24 December 2021

## **SANCROX QUARRY EXPANSION PROJECT (SSD-7293) – RFI RESPONSE TO FURTHER EPA ADVICE**

We refer to your correspondence of 25 November 2021, requesting a response to the issues raised in the EPA's further advice on the Sancrox Quarry Expansion Project (reference: DOC21/914564-05; EF13/3037).

Table 6.1 *Conceptual Basin Sizing*

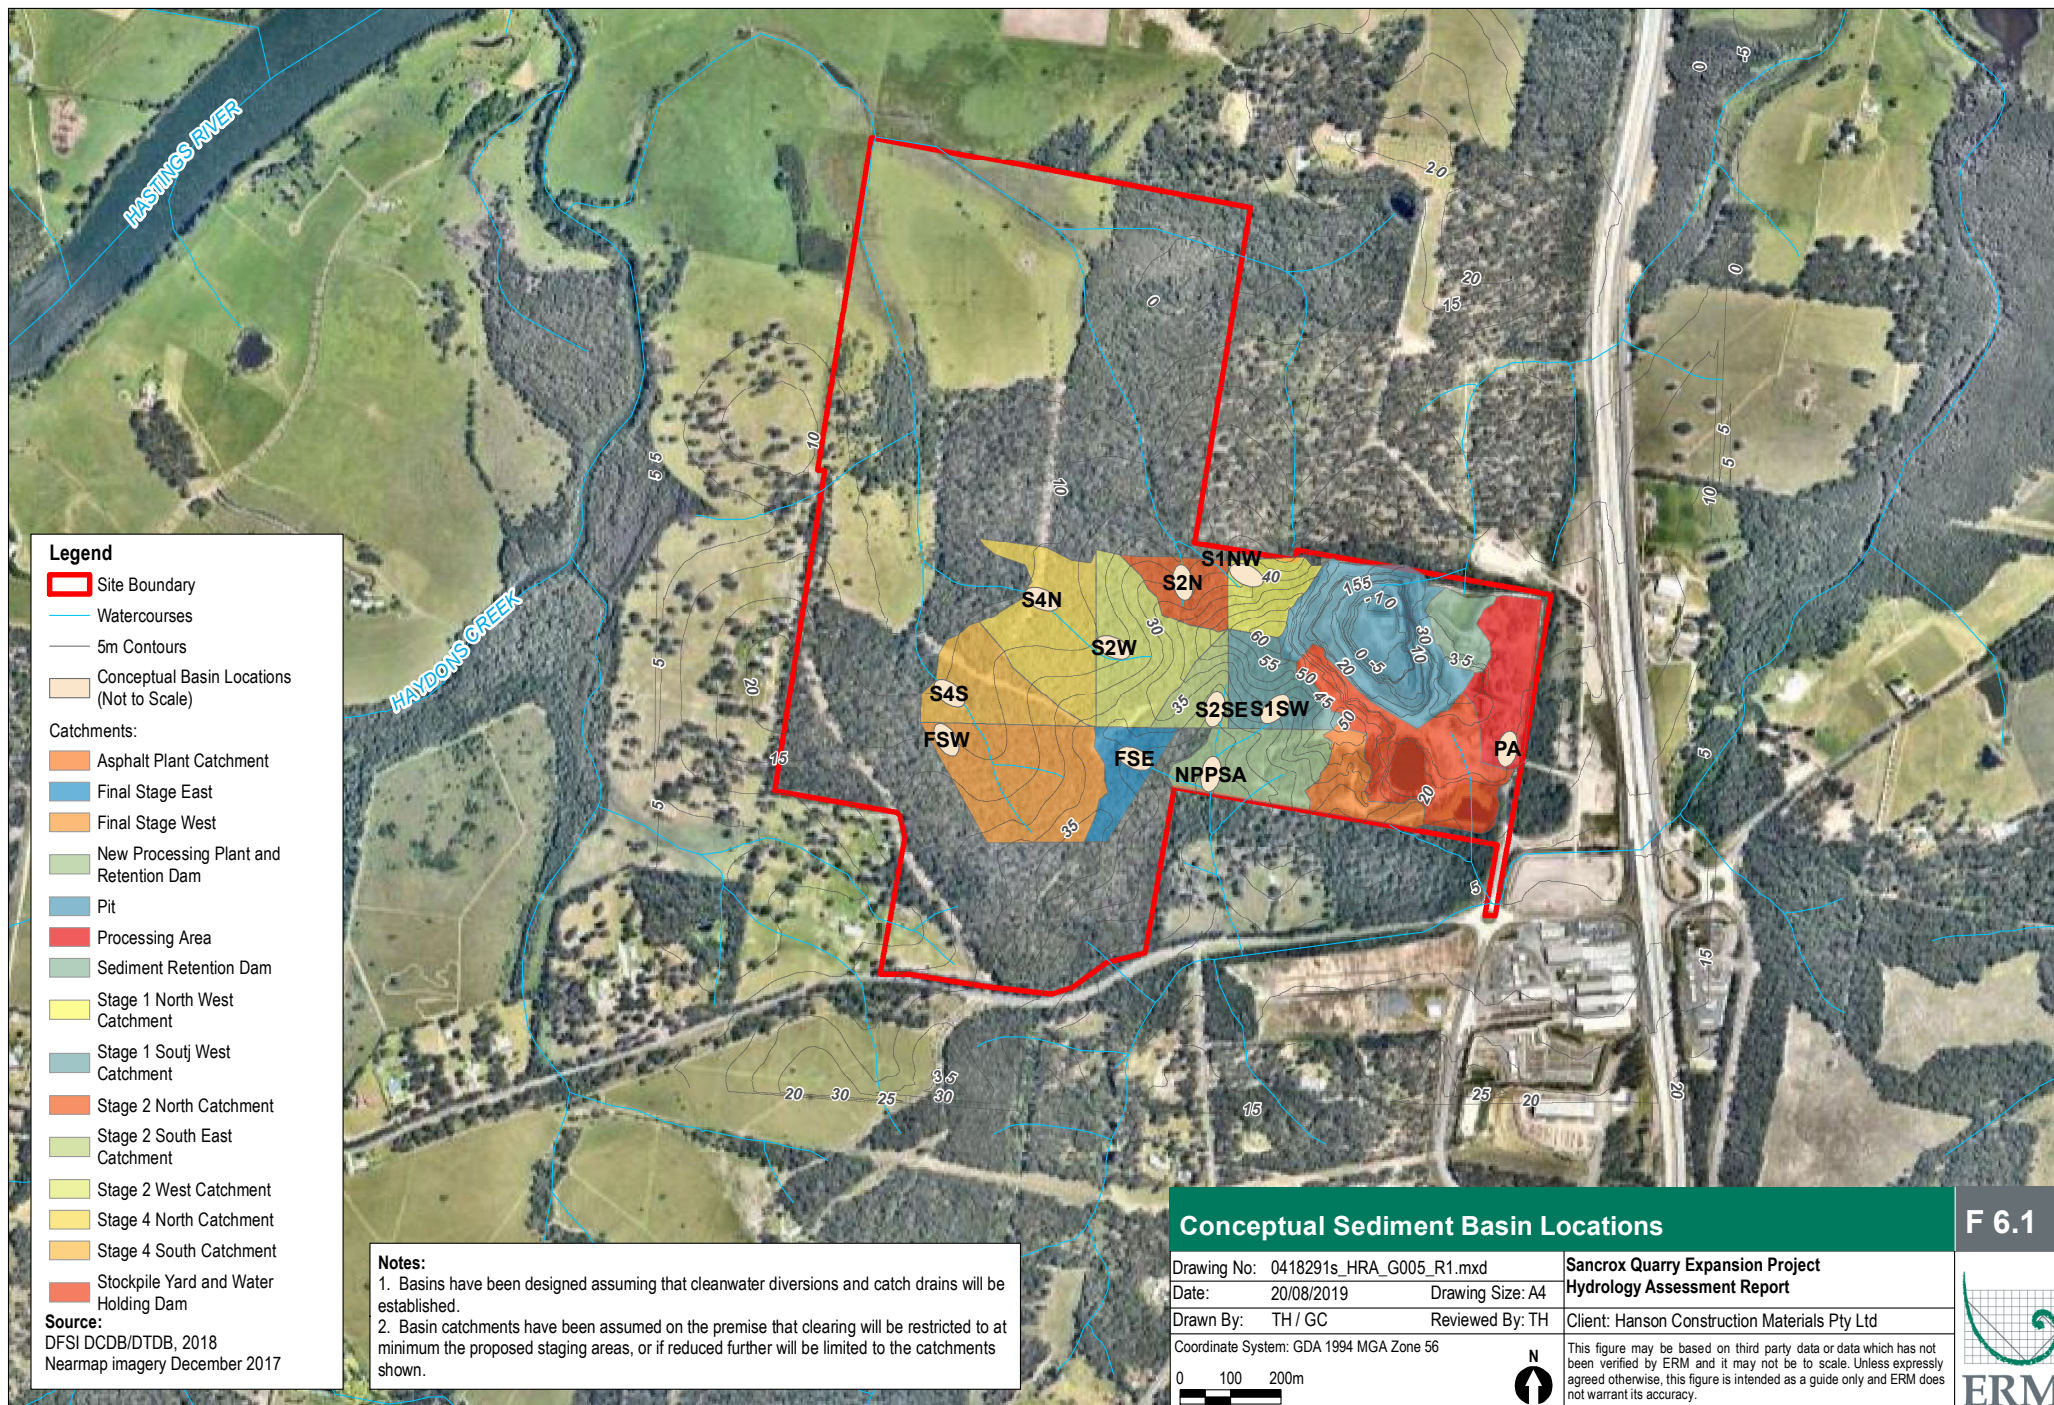
#### **(a) Water Quality – sediment basins have not been adequately sized.**

- *The design storm event used in the conceptual sediment basin design was the 80th percentile, 5 day storm event of 40.1mm (as recommended for a basin with an operational lifetime of 1 – 3 years, discharging to a standard sensitivity environment, in Table 6.1 of Managing Urban Stormwater: Soils and Construction - Vol 2E, Mines and Quarries).*

- *However, the proposed quarry life will be 30 years. It is therefore assumed that the duration of disturbance from the proposed basins will exceed 3 years.*

- *In addition, the site flows to mapped coastal wetlands protected under State Environmental Planning Policy (Coastal Management) 2018 (Coastal Management SEPP 2018). Proposed basins S1NW, S2N, S4N and S4S flow to mapped Coastal Wetlands to the northwest of the site. Proposed basin NPPSA flows to a mapped Coastal Wetland to the east of the site.*

- *The EPA requests clarification and justification as to why the 80th percentile 5-day storm event (design storm event) was used to guide basin capacity. Consideration should be given to the proposed basin life, sensitivity of the receiving environment and the Coastal Management SEPP 2018.*

The EPA's assumption that the duration of disturbance from the proposed basins will exceed 3 years is incorrect. The conceptual basin design illustrated all of the basins cumulatively. However, basins will be delivered in a sequential basis, aligned with the staging of the quarrying activities. This means that only basins relevant to each stage of quarrying activities will be constructed and operational during that stage. Further the basins are only relevant and operational during the early phases of quarrying for each stage. Once sufficient quarrying has been carried out within each stage the pit forms a natural void, directing water away from discharge points. During these phases of quarrying, water falling within the quarry pit will be collected for reuse, and no water will be able to discharge towards the natural watercourses based on current topography. Rather, any excess water collected within the quarrying pit will be directed via the existing quarry void into the existing Sediment Retention Dam and Water Holding Dam network, which together have over 17,000m<sup>3</sup> worth of water storage capacity.

In relation to the sensitivity of the receiving environment, we note that the Coastal Management SEPP 2018 does not apply, since the quarrying development works are not within the areas mapped as Coastal Wetlands or as a Proximity Area for Coastal Wetlands by the online Coastal Viewer tool published by the Department of Planning, Industry and Environment.

With consideration of the above, it is considered reasonable to base the conceptual sediment basin design on an operational lifetime of 1 – 3 years, with discharges to a standard sensitivity environment. However, we note that there will be short periods of time within the early periods of each quarry stage when the installed sediment basin may still discharge along existing creek lines towards the identified Coastal Wetlands. As such, it would be a simple alteration for Hanson to ensure that sediment basins were designed for the 85<sup>th</sup> percentile storm event (rather than the 80<sup>th</sup> percentile), thereby reflecting the sensitive nature of the receiving environment during these times. Further, it is highlighted that there are no real limitations or constraints in relation the sizing of basins within the quarry footprint. As such, if it is deemed necessary by the Department of Planning, Industry and Environment (on the advice of the EPA) then Hanson could increase the size of the basins to account for the 95<sup>th</sup> percentile storm event, reflecting the worst case scenario of a basin with an operational lifetime of more than 3 years, with discharges to a 'sensitive' environment – notwithstanding that this would be considered to be an unnecessarily overly conservative application of the Managing Urban Stormwater: Soils and Construction - Vol 2E, Mines and Quarries guideline.
